PERSIMMON HOMES THAMES VALLEY

Application under Section 96A of the Town and Country Planning Act 1990 for alteration to approved Door Position on plot 121 at Phase 2, Land North of Toddington Lane, Littlehampton

Planning Portal Reference: PP-09335449

Drawing Title:
WPLTH3520A and WPLTH3520C
Proposed Plans - Plot 121

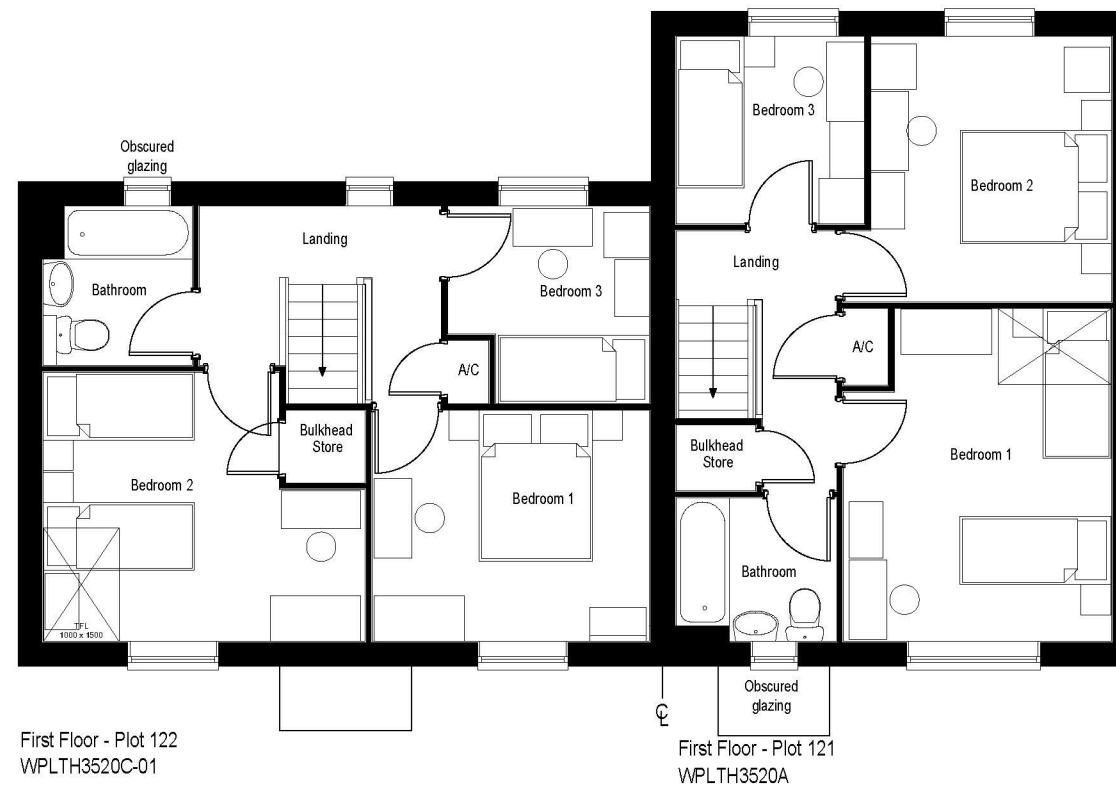
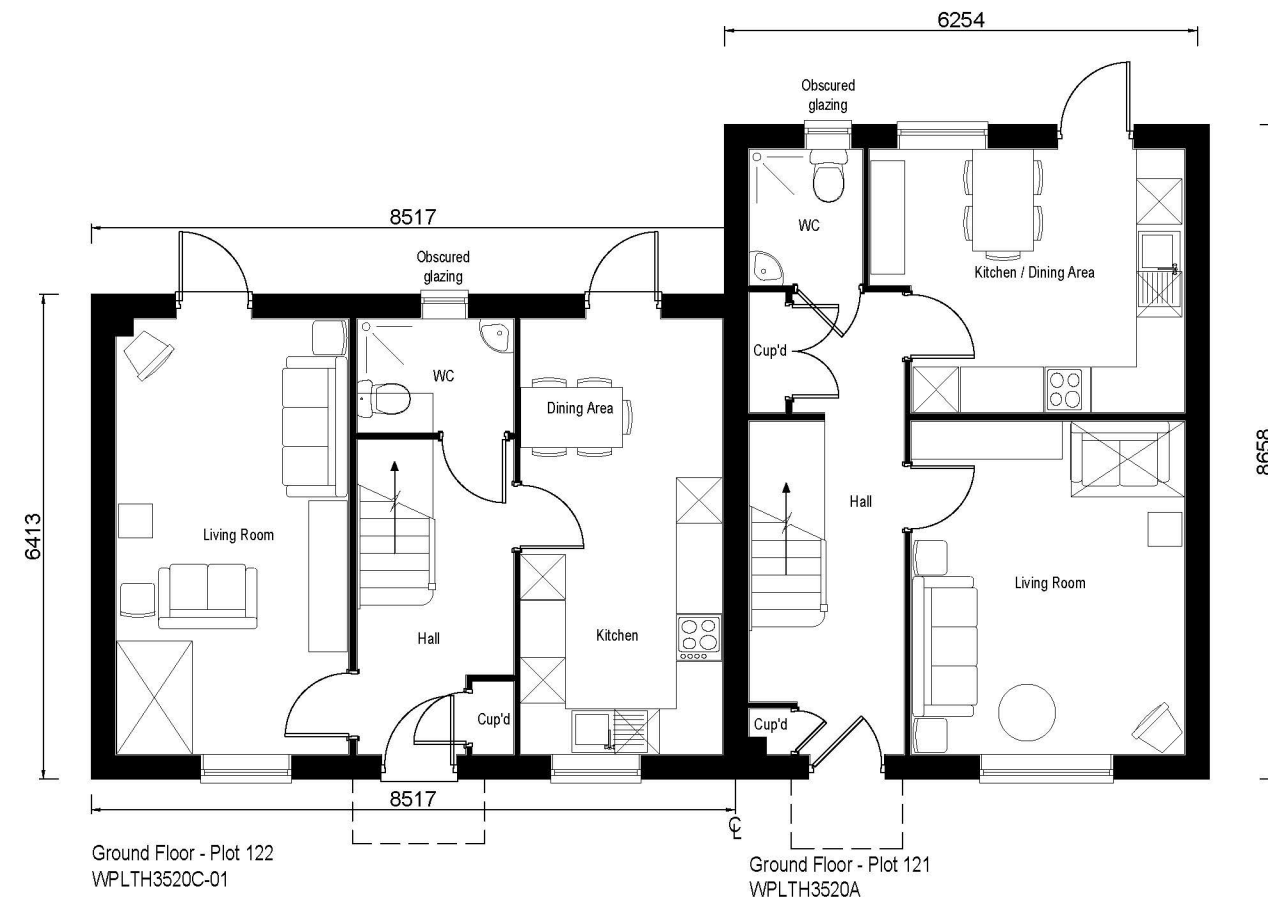
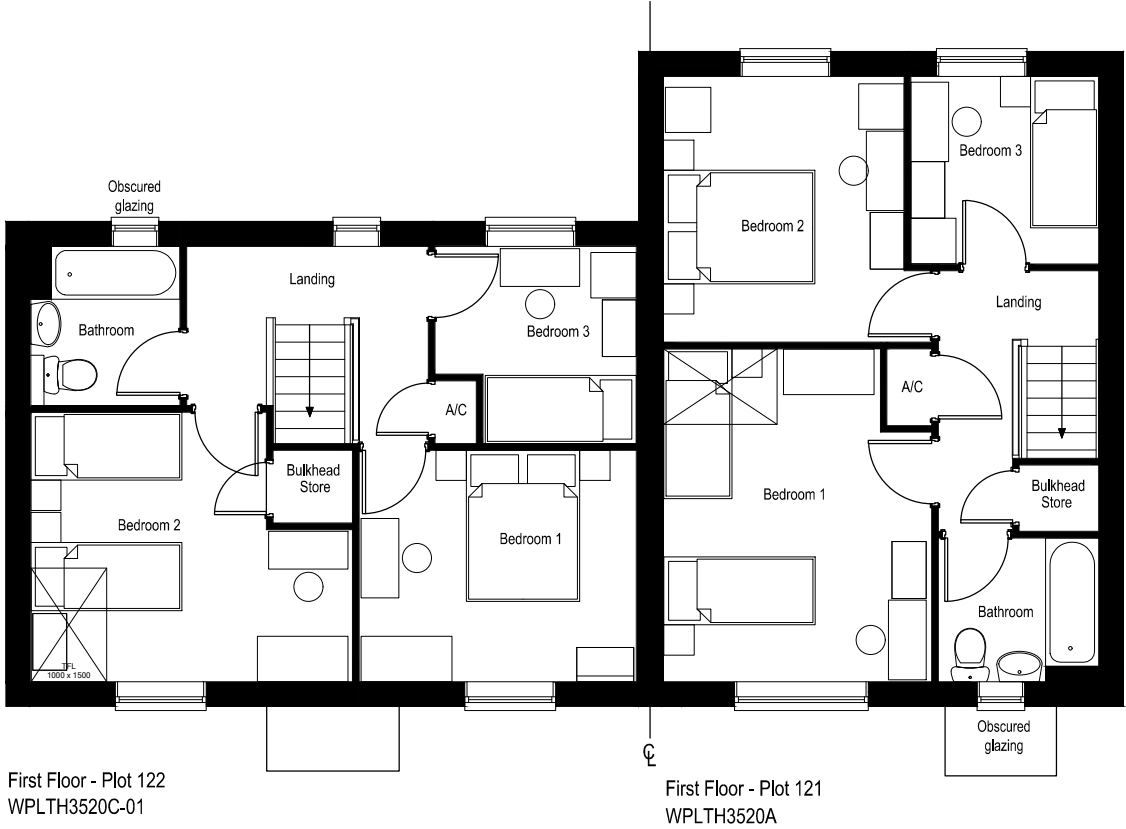
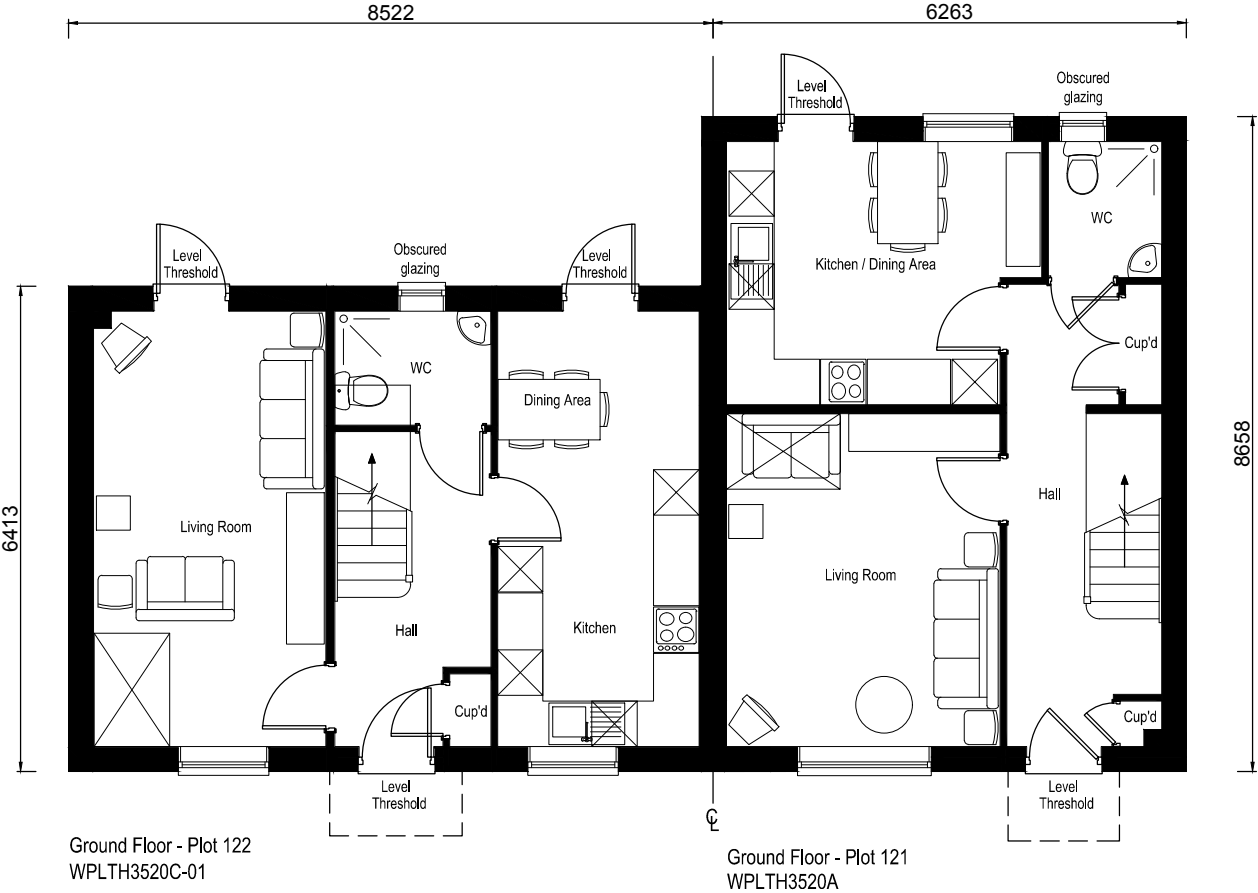
The approved drawings form part of this application and show the front door of plot 121 to be on the left hand side of the property. This application is being made to regularise a change on site which has the front door situated on the right hand side of the property. There are no other changes to what has previously been approved.
